Application H12-0518-16
Location Adjacent: 2 School Lane Lutton Spalding PE12 9HW
Proposal Erect pair of 3 bedroomed semi-detached houses (re-submission of H12-0281-16)

Name Louise Jennings Historic Environment Officer
Address Historic Environment Officer Lincolnshire County Council Witham Park House LN5 7JN

Date Submitted 21-06-16
For/Against Comments

TREE PLANTING / LANDSCAPE SCHEME

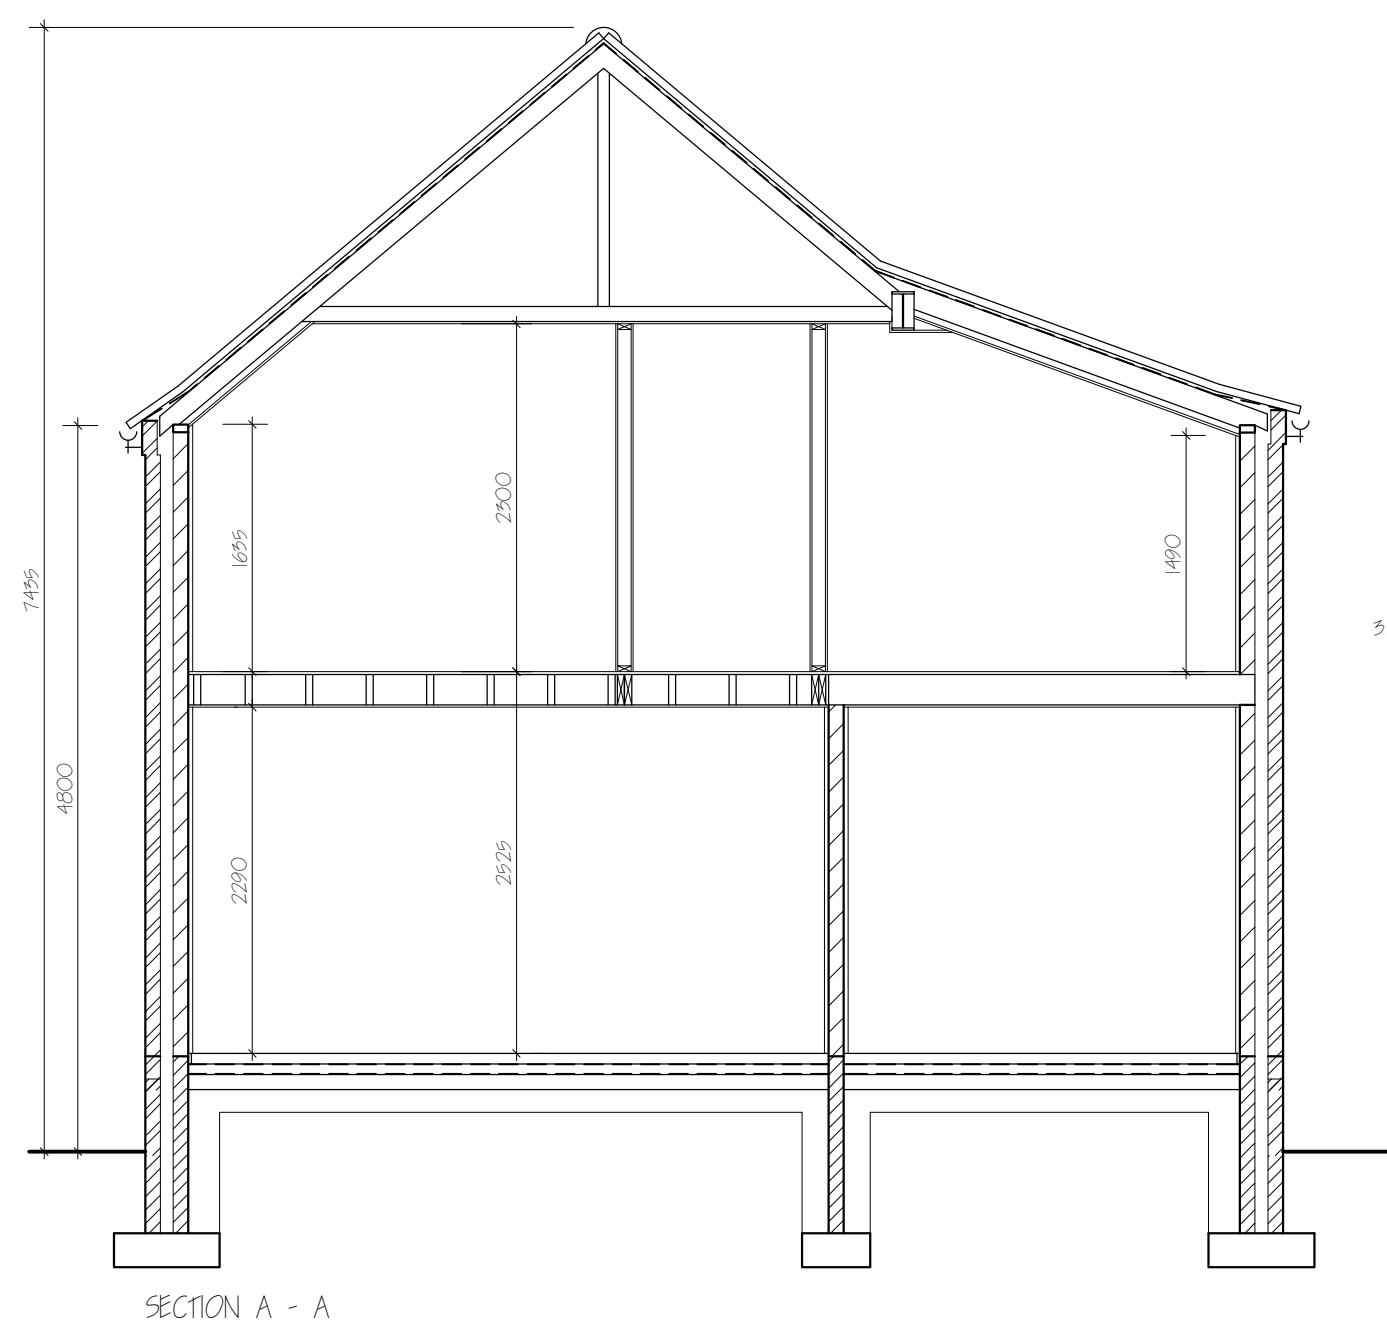
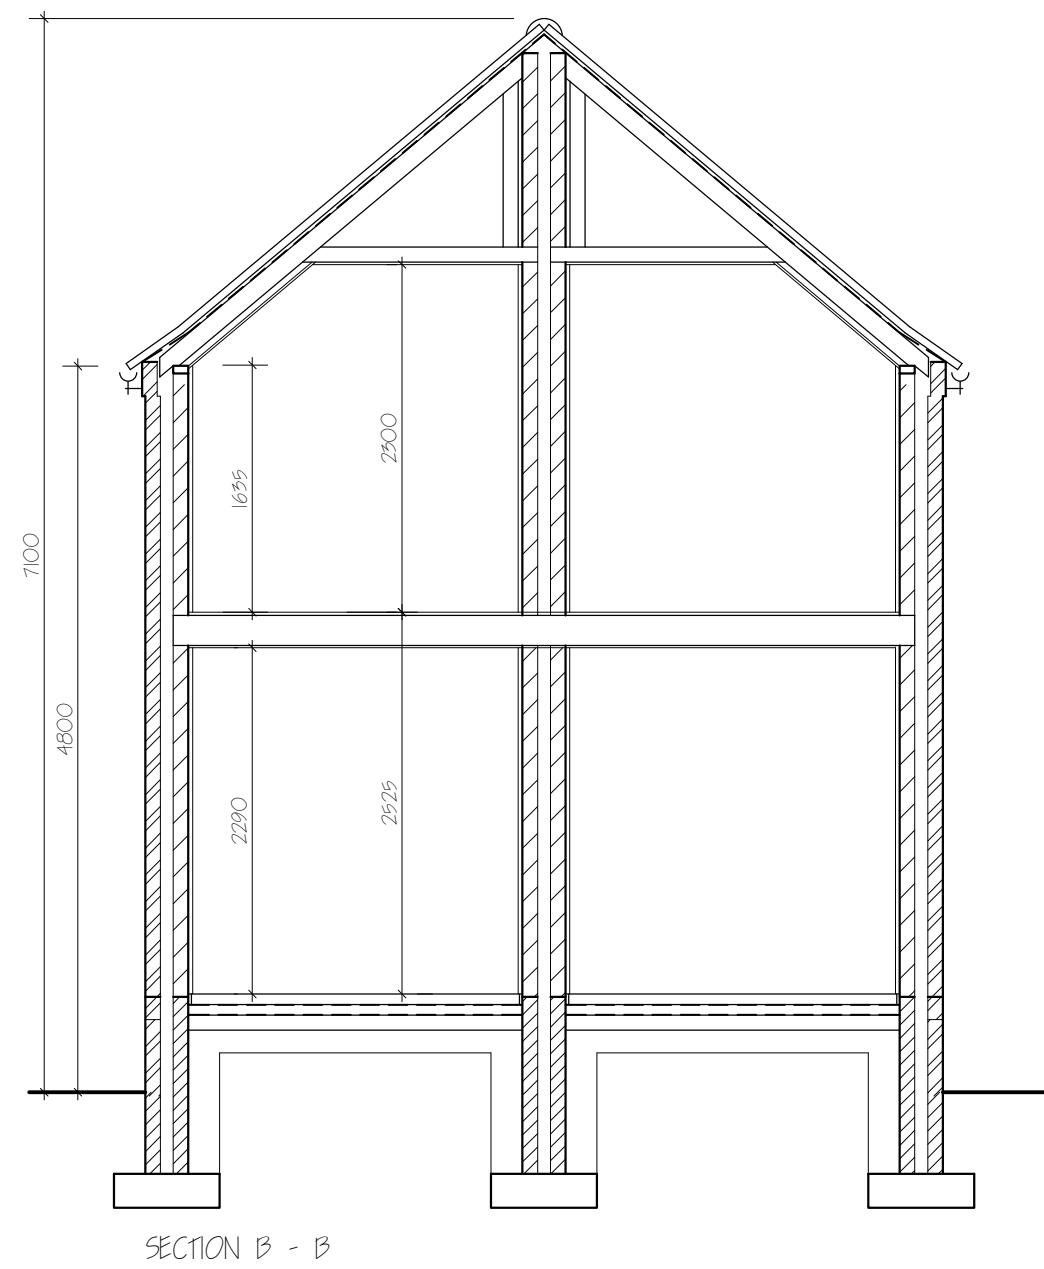
The cottage on this site is possibly eighteenth century and despite the extension of more recent date it is of historic interest. Parcelling off part of the garden and erecting two semi-detached modern houses will destroy the historic relationship between this Cottage and its original boundaries.

In addition to this, this site lies within the heart of Lutton, the land pattern suggests that this area was inhabited at least as early as the medieval period and possibly earlier. Any development of this site could disturb archaeological remains relating to this period.

Given this, I would recommend that the development be refused.

However if permission should be forthcoming I recommend that an archaeological scheme of works condition (4.8.1 in the archaeological handbook) is attached to any permission to enable archaeological remains within the site to be recorded prior to their destruction. Therefore given this it is recommended that the developer should be required to commission a Scheme of Archaeological Works (on the lines of 4.8.1 in the Lincolnshire Archaeological Handbook (2012)). This should be secured by South Holland District Councils Standard Conditions AR01, 02 and 03.

Initially I envisage that this would involve monitoring of all groundwork's, with the ability to stop and fully record archaeological features.
